KIRKLEES METROPOLITAN COUNCIL INVESTMENT & REGENERATION SERVICE

DELEGATED DECISION TO DETERMINE PLANNING APPLICATIONS

Reference No:	2023/62/93189/E
Site Address:	51, Kitson Hill Road, Mirfield, WF14 9HA
Description:	Demolition of existing extension and erection of two storey side and single storey rear extensions
Recommending Officer:	Elenya Jackson

OFFICER REPORT: 2023/93189

SCALE : 1:50

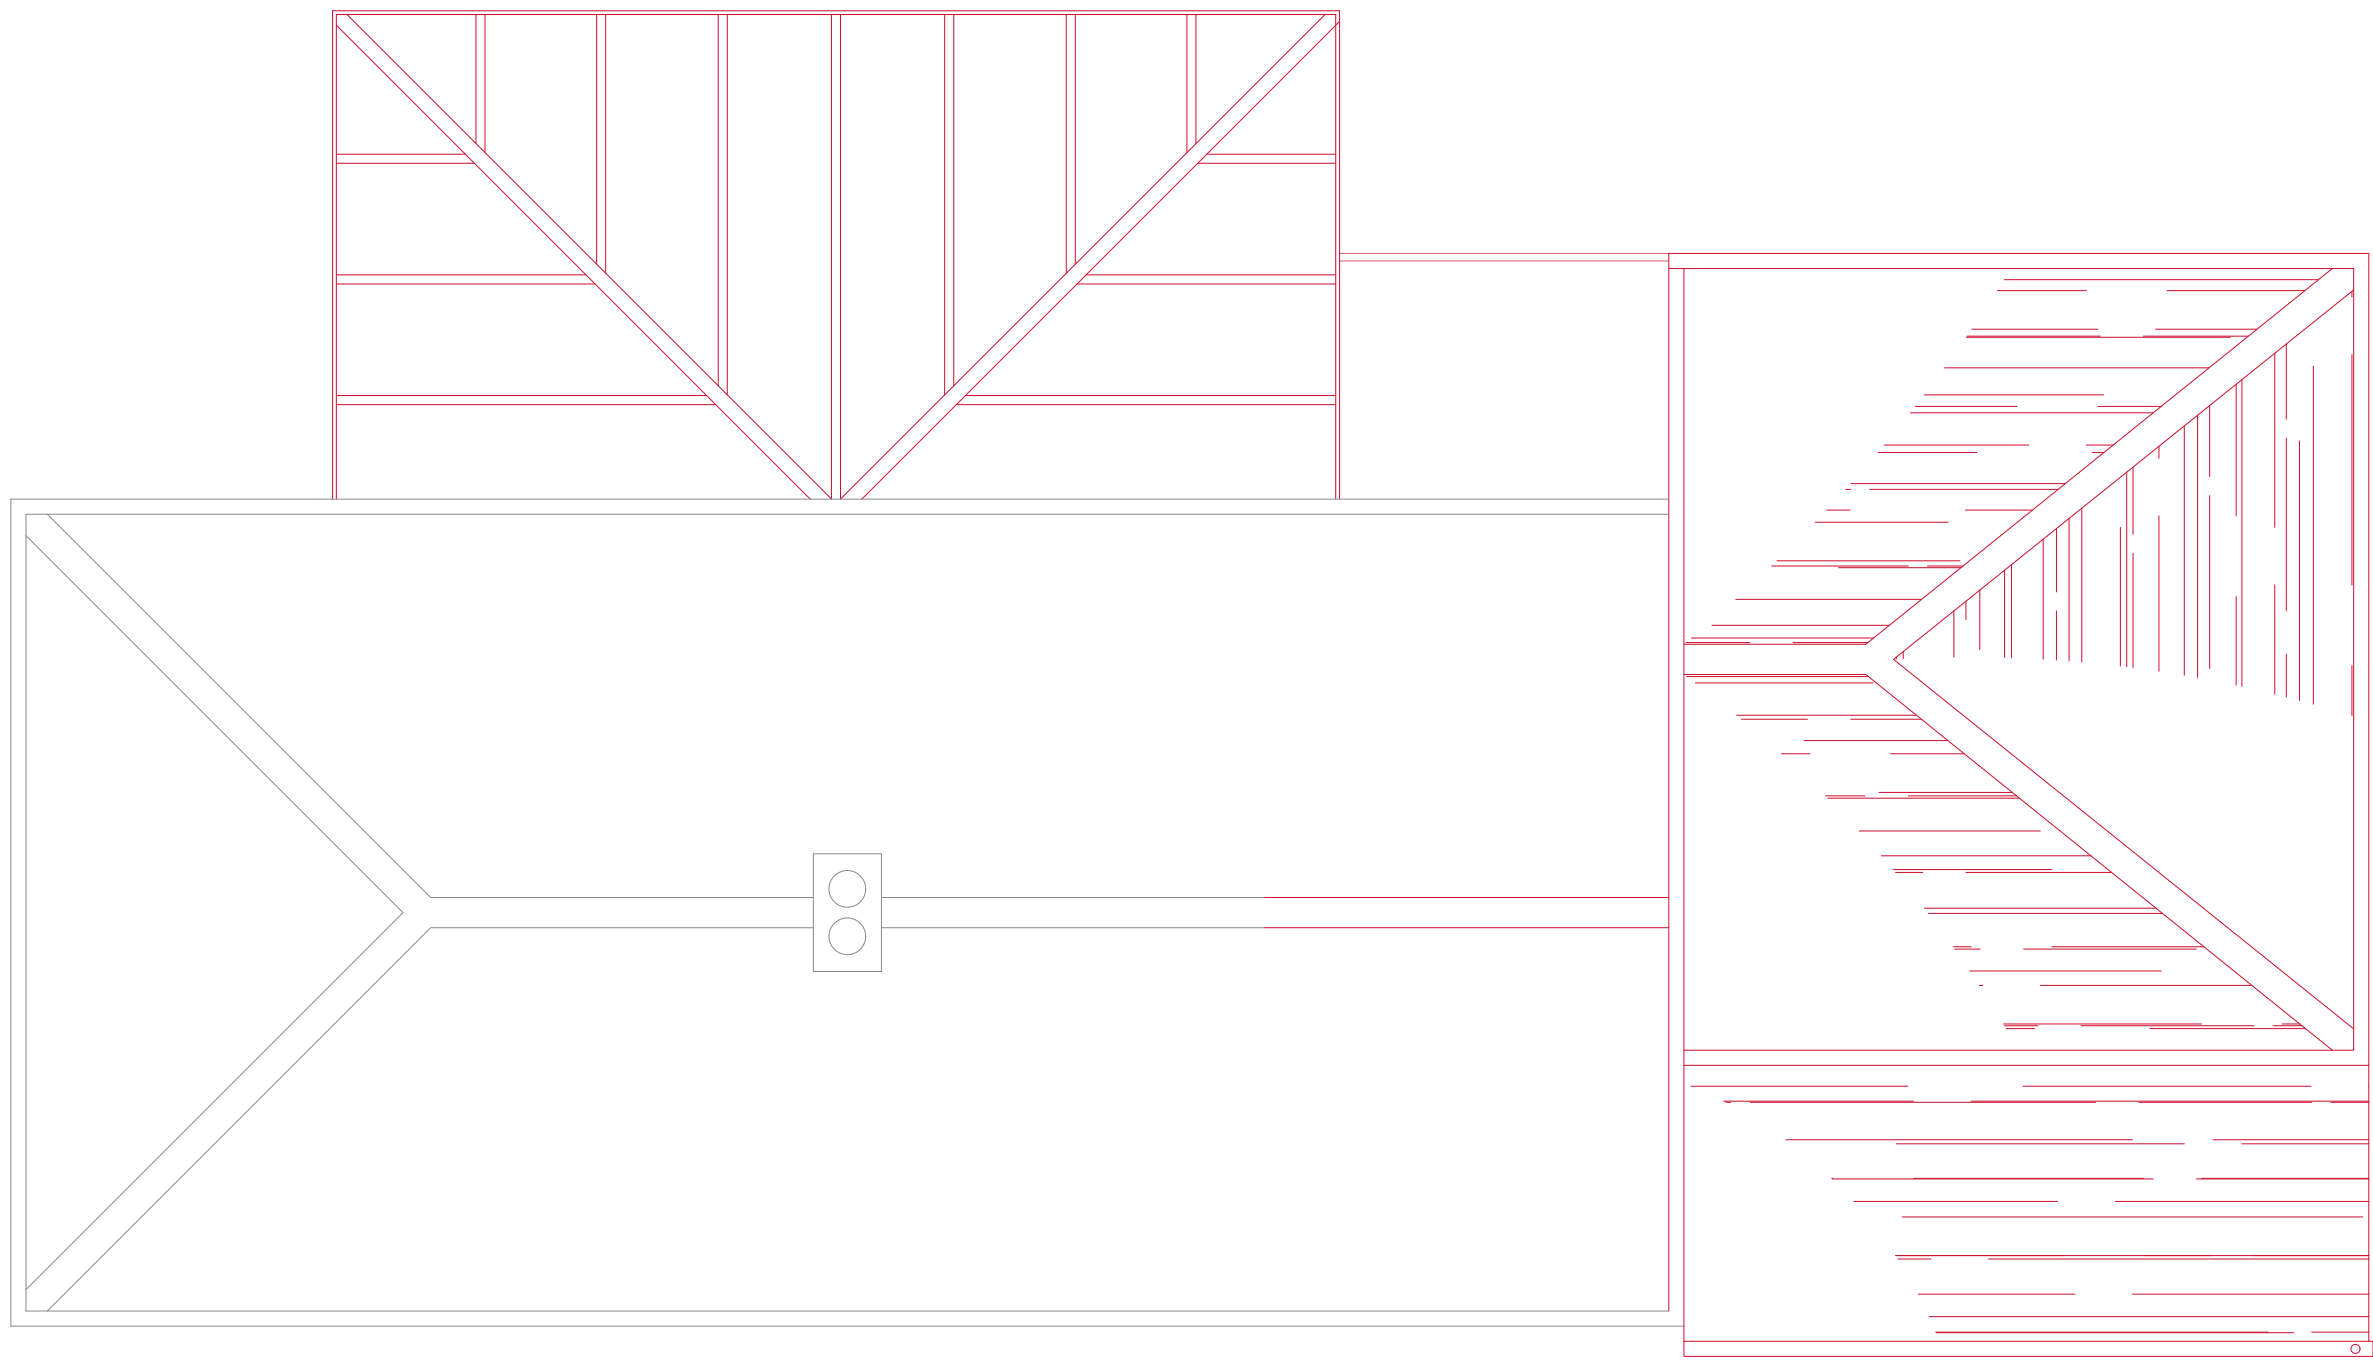
Impact on 53 Kitson Hill Road: adjoins the application property to the west. Overlooking: The proposed rear extension would feature side facing windows. No.53 features two first floor side facing windows which feature obscured glazing. The side facing windows in the orangery would be set a reasonable distance from the shared boundary and not be the only vantage point from the orangery. In relation to the side extension, this would be set forward and at an angle to No.53 such that no loss of privacy would result to the occupants of No.53.

The proposals would result in the intensification of the domestic use of the site due to it creating four bedrooms. The site currently has a driveway and the plans indicate 3 parking spaces would be retained. The proposal would not result in the loss of any parking spaces on site and the site does have additional space should further parking be required., it is considered that due to no spaces being lost as a result of the proposal, the proposal is considered to comply with Policy LP22 of the Kirklees Local Plan along with Key Design Principles 15 & 16 of the House Extensions & Alterations SPD.
